Letter of Intent
Site Development Plan

Hammers Construction, Inc.
1411 Woolsey Heights
Colorado Springs, CO 80915
Project Name: CBP2-7-1

Letter of Intent_V1.pdf Markup Summary

CBP 2,7-1  
1716 GARY WATSON POINT  
COLORADO SPRINGS, CO 80915  
EL PASO COUNTY, COLORADO

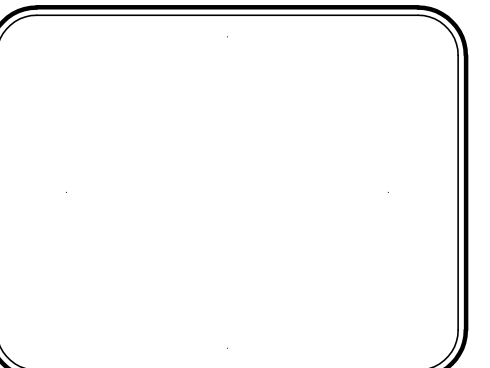
This is confusing, should it be 2-1-7?
